Please ask for: Mrs D Johnson
Email: daun.johnson@arun.gov.uk
Telephone: 01903 737762
Our Ref: AL/72/22/PL
Your Ref:
Date: 25th May 2022

Application for Planning Permission

Development: Demolition of Servac Int workshops; 1 No 2 bed annexe over parking bays with courtyard at front of annexe and two storey extension of current 2 storey rear structure keeping certain structures & features, to renovate them into a 2no. car port, with storage loft, re-landscaping to provide new gardens and biodiversity zones.

Location: Rock House Westergate Street Westergate PO20 3RJ

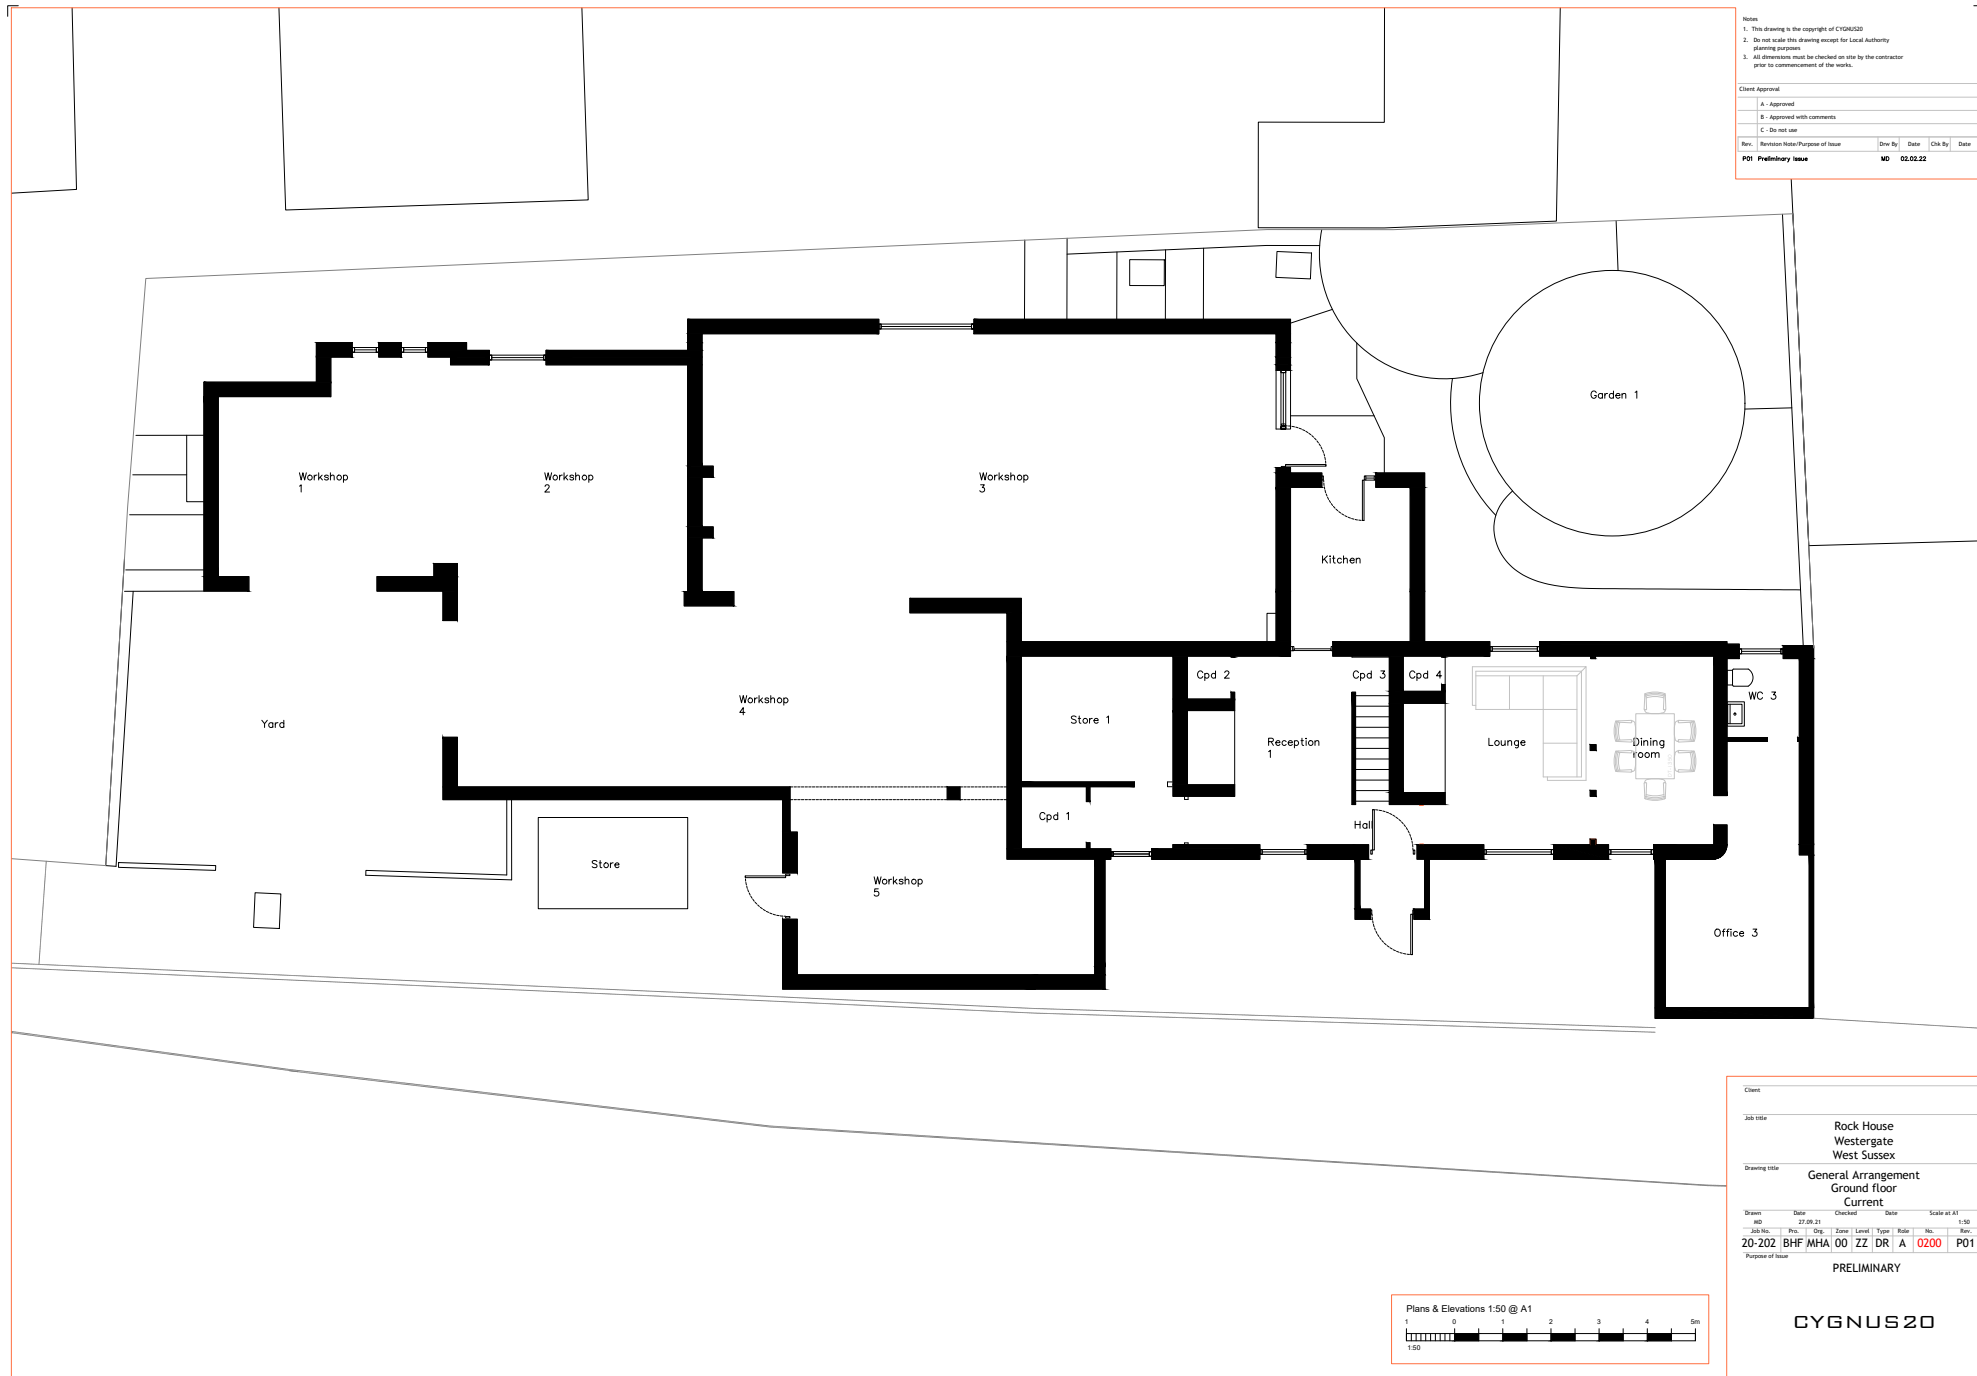
The ground floor plan and proposed north elevation do not accord at the office. Please amend accordingly.
